Harnett County Government Complex
307 Cornelius Harnett Boulevard
Lillington, NC 27546

August 15, 2007

Re: Status of Improvement Permit Application #07-5-17592R
Lt 4 Cypress Woods

Wesley Wright  
07-50017592R  
Lot 4 Cypress Woods

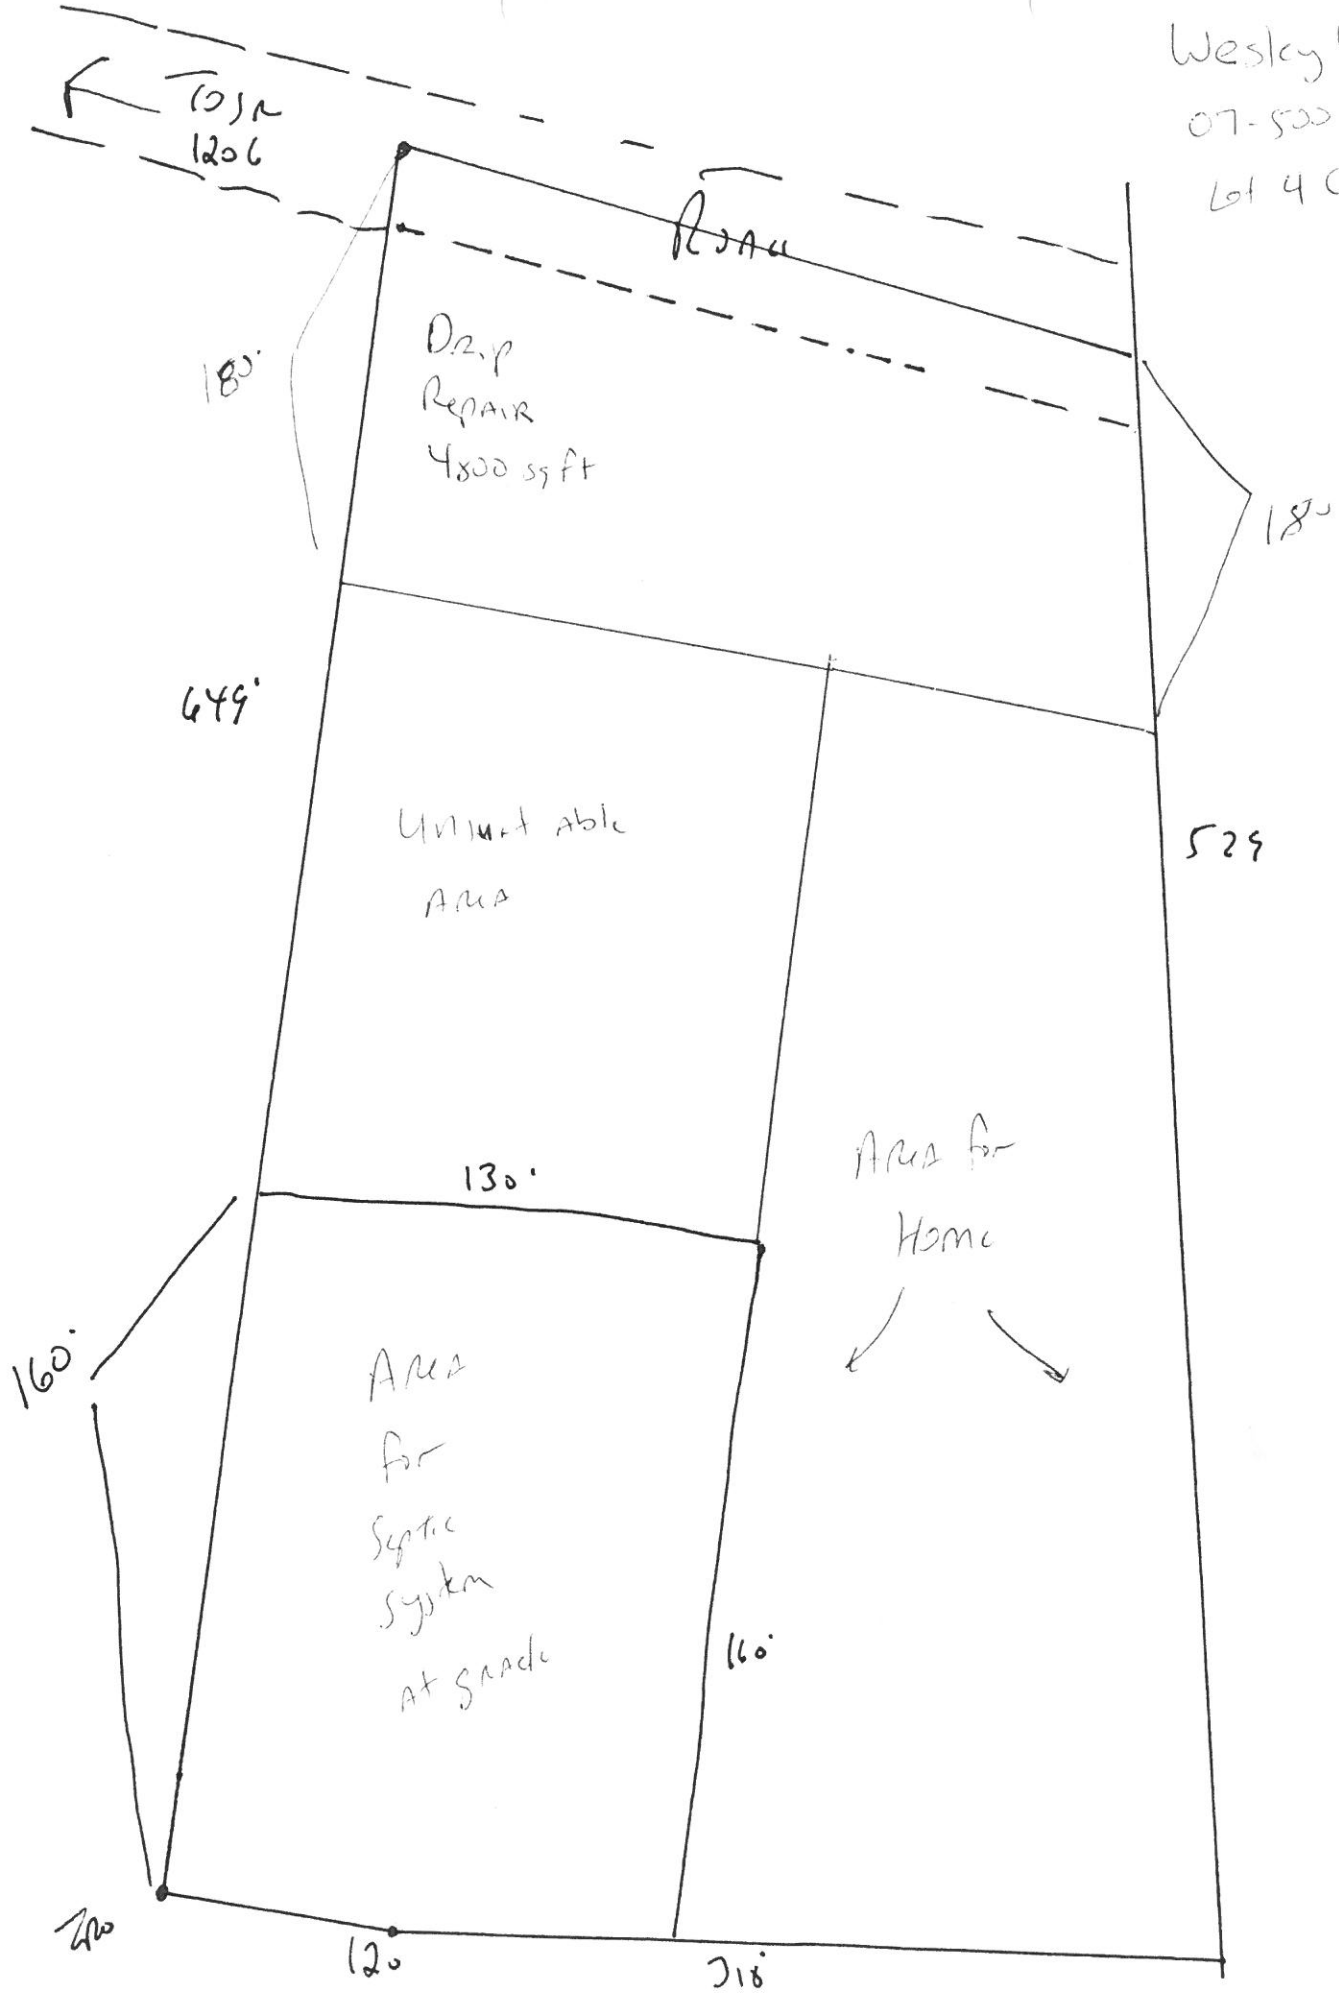
6. Other – Move house out of area marked septic area and repair area. (See attached) Submit new plot plan to Central Permitting.
